A41 - Oxford Road

Bicester

Linsig Report

August 2018

**Scenario 5: '2026 PM BTM + Committed + Proposed'** (FG19: '2026 PM BTM + Committed + Proposed', Plan 1: 'Control Plan')

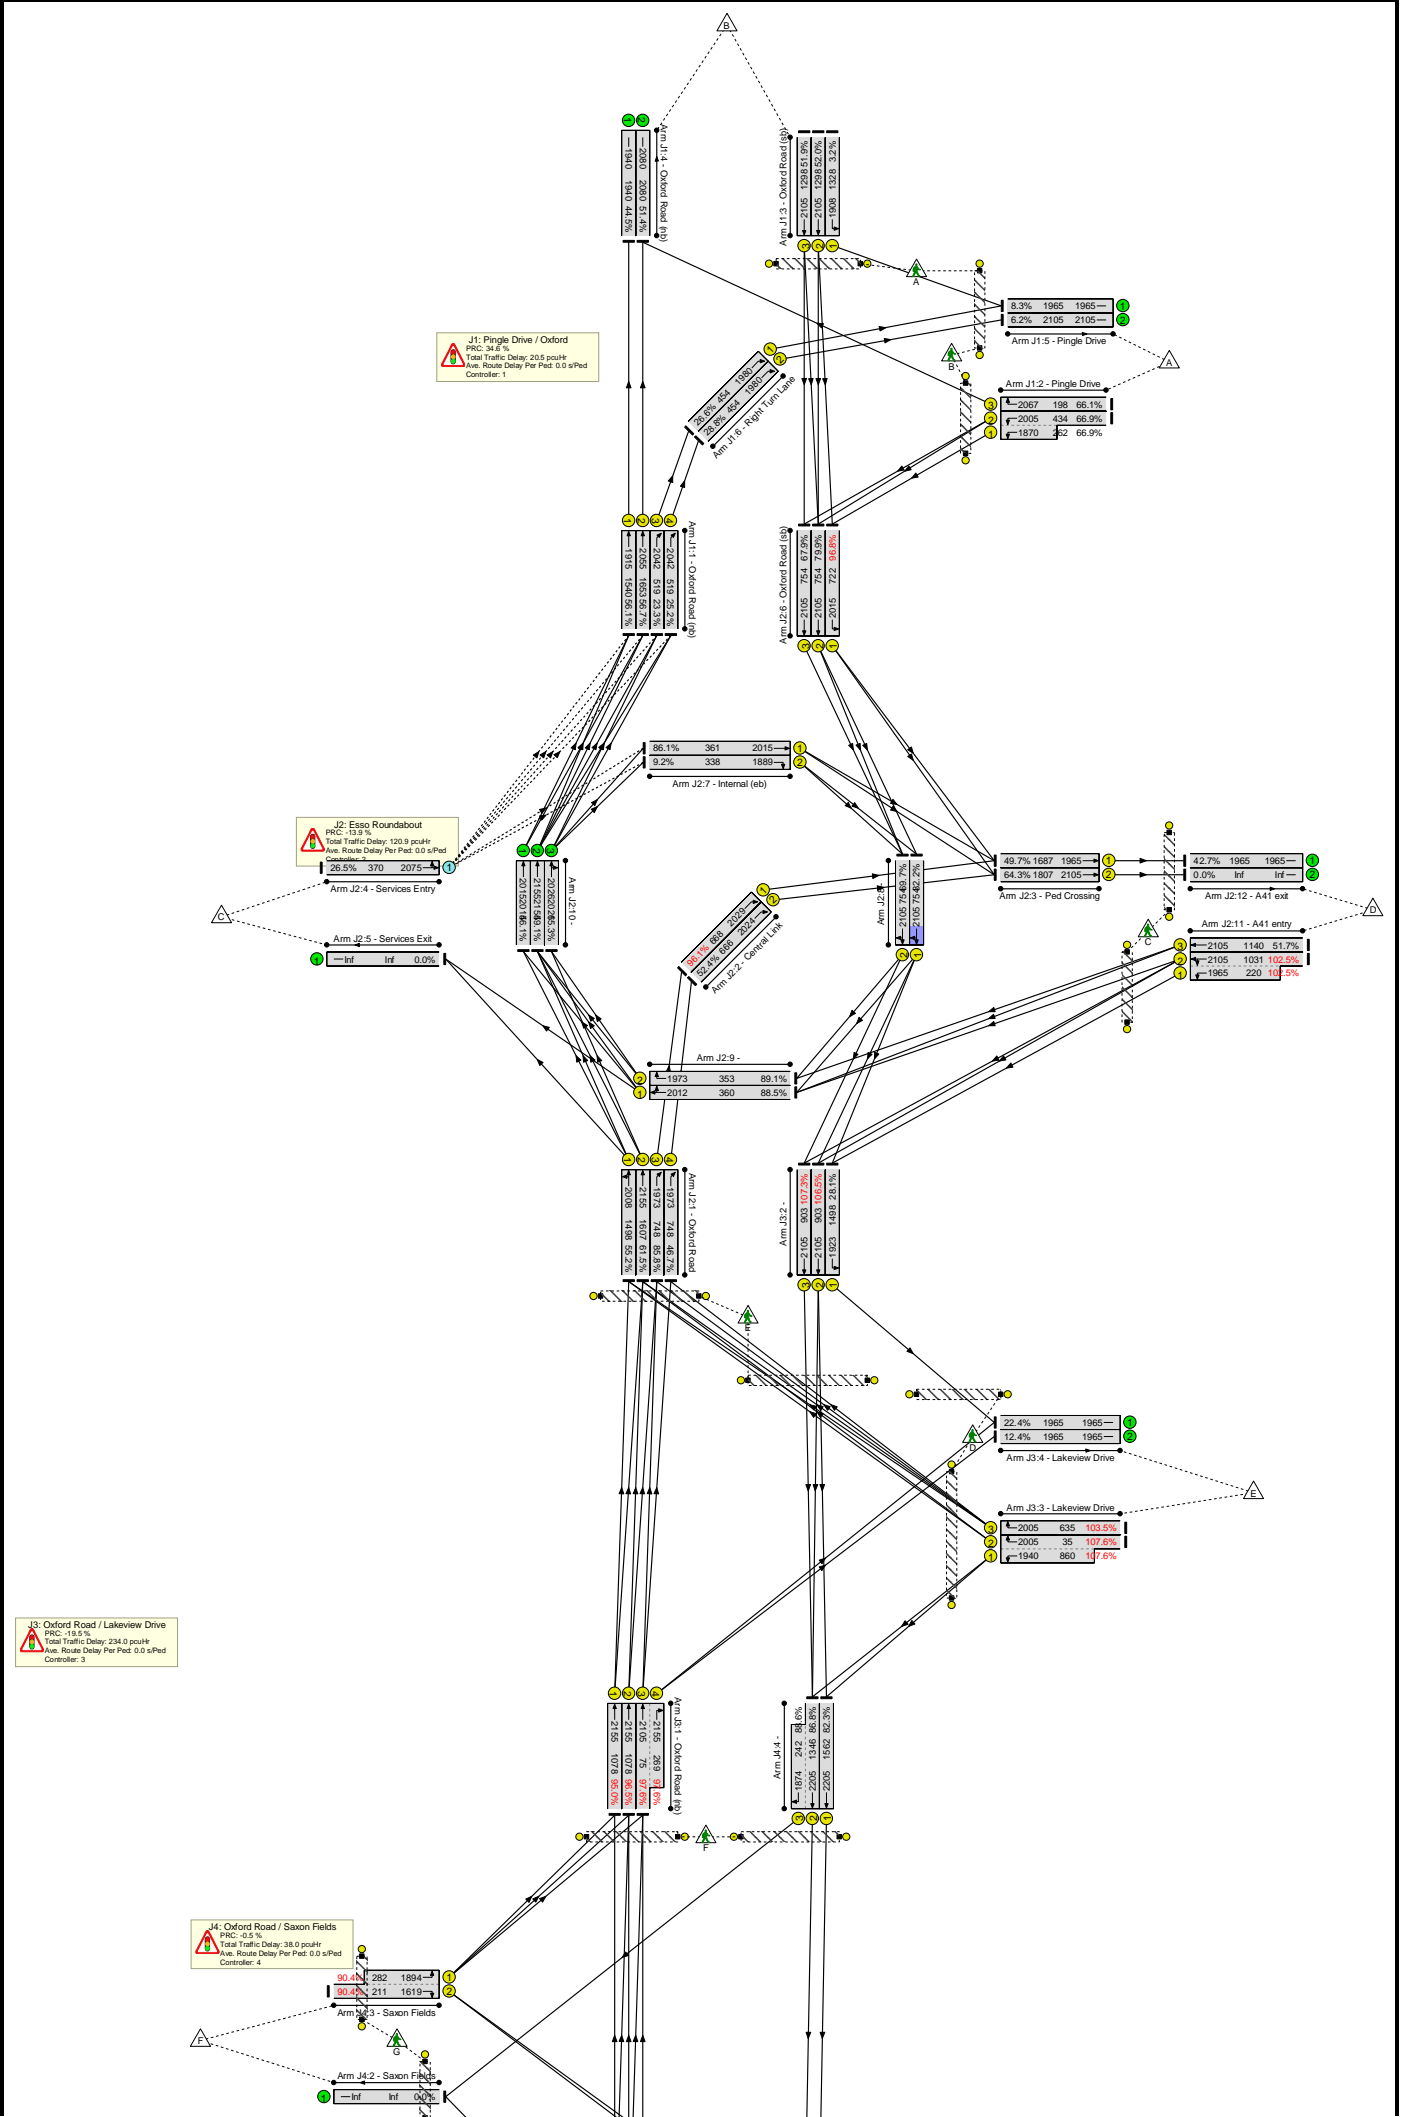
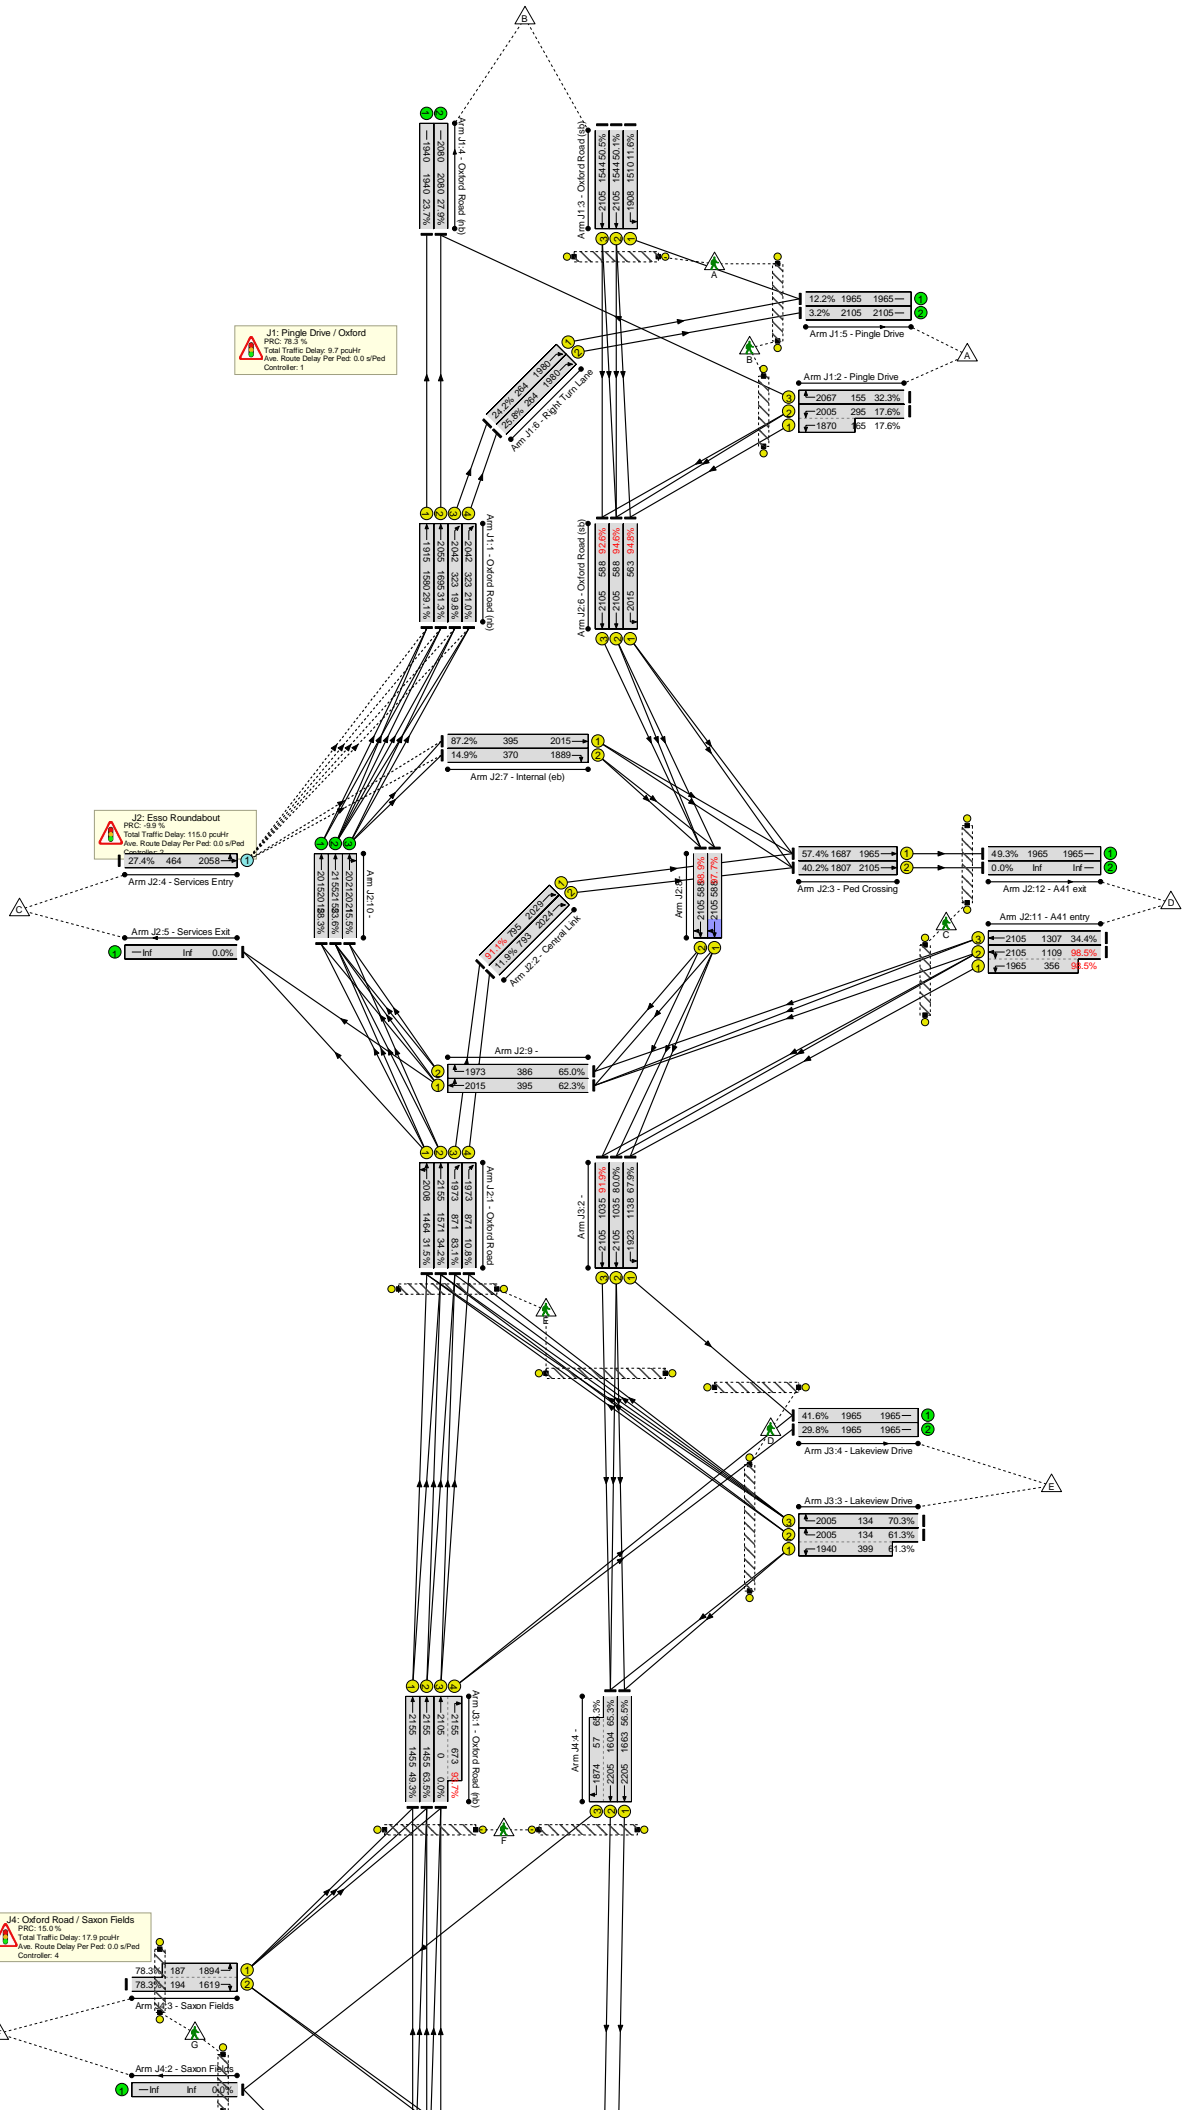
Both models are similar, other than the changes highlighted in the Transport Assessment. There are a number of problems with the modelling, most of which affects both models. Both have two significant warnings in the Linsig Error View:

- Give Way Lane J2:4/1 has no opposing lanes specified. This is incorrectly configured and will affect the result, giving an unrealistically high capacity for this approach. This should be corrected.
- Matrix Estimation indicates that not all turning counts have been entered. If Matrix Estimation is being used, this should be completed. Otherwise, it would be prudent to remove the remaining data to avoid confusion or mistakes.

Use of lane connectors to allow weaving will allow overly optimistic distribution of traffic flows and allows inappropriate route selection. If / where lanes are not immediately available at the exit of the previous junction, intermediate exit lane lanes may be required to accurately model lane and route choices. Alternatively, route flows may need to be manually set to manage traffic flows on weaving connectors. If this is done, the weaving flows should ideally be based on observed figures.

Lane J2:11/1 only links to Lane J3:2/1. This may be correct, however it limits traffic assignment in Lane J2:11/1. If this is accurate, the difference between the Base and Model appear correct; if this is not accurate, then some of the benefit of the mitigation is artificial.

As highlighted in the error warning, J2:4/1 is configured as give way, but opposing lanes have not been entered for the movements to J1:1/1 or J1:1/4.

We would recommend that the errors in the model be corrected and the modelling resubmitted.
